SSD 77020757 – OAKDALE EAST PRECINT 2 – ENVIRONMENTAL IMPACT STATEMENT – FAIRFIELD COUNCIL SUBMISSION

This letter responds to the Environmental Impact Statement (EIS) prepared by Goodman associated with the SSDA for of Precinct 2 of the Oakdale East Industrial Estate. Council has reviewed the EIS report and attached supporting documentation and provides the following comments on the EIS.

DA	
Total Canopy	Size
Lot area (including carpark and buildings)	157,492 sq m
Proposed mature canopy (Precinct)	8,521 sq m

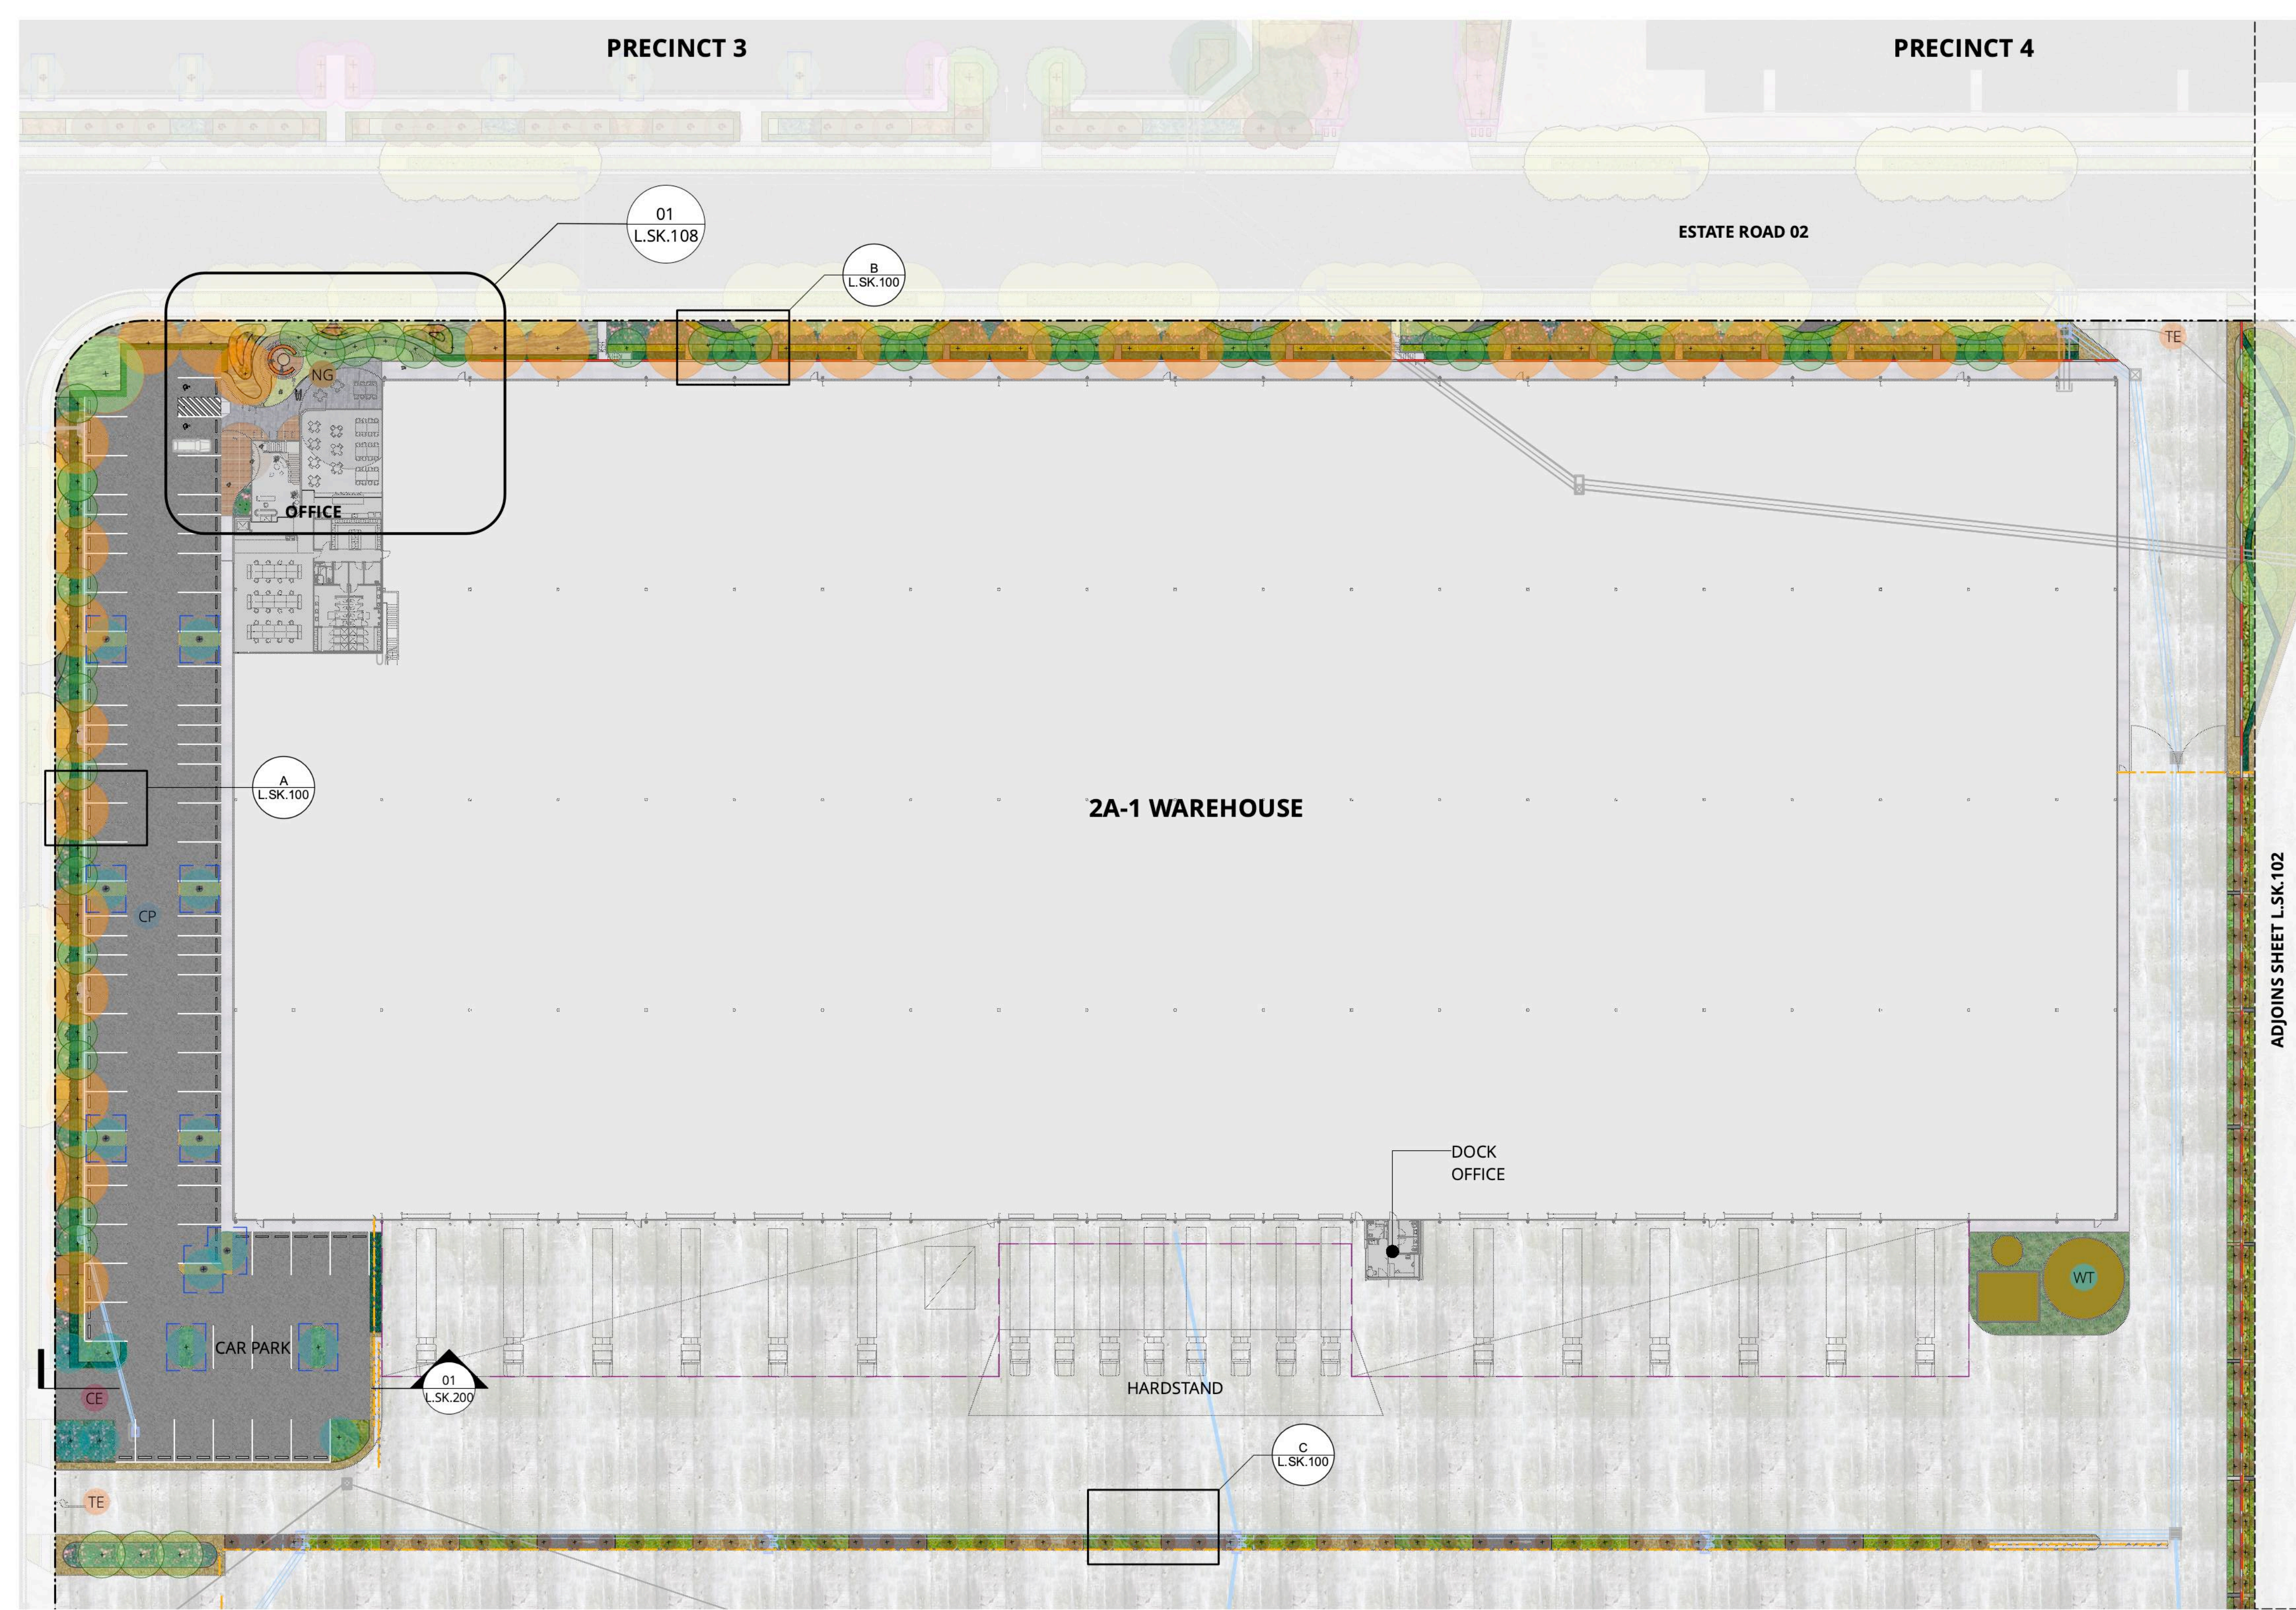
- 2. Canopy Coverage and Pervious Area Requirements** – The landscape plan shows a mature tree canopy coverage of 5.41% for precinct 2. Council notes the requirement within the DCP for canopy coverage, including 10% of the lot to be covered by tree canopy (once mature) and this area excludes public roads and non-industrial lands. It is requested the landscape design be modified to show 10% mature canopy coverage can be achieved.

Council notes minor non-compliances with the Oakdale East DCP specifically mature landscape cover. The landscape plan should be resubmitted to show how 10% mature canopy coverage can be achieved on the lot. In addition, the conditions recommended by Council officers above must be included in any consent should the DPH&I approve the SSDA.
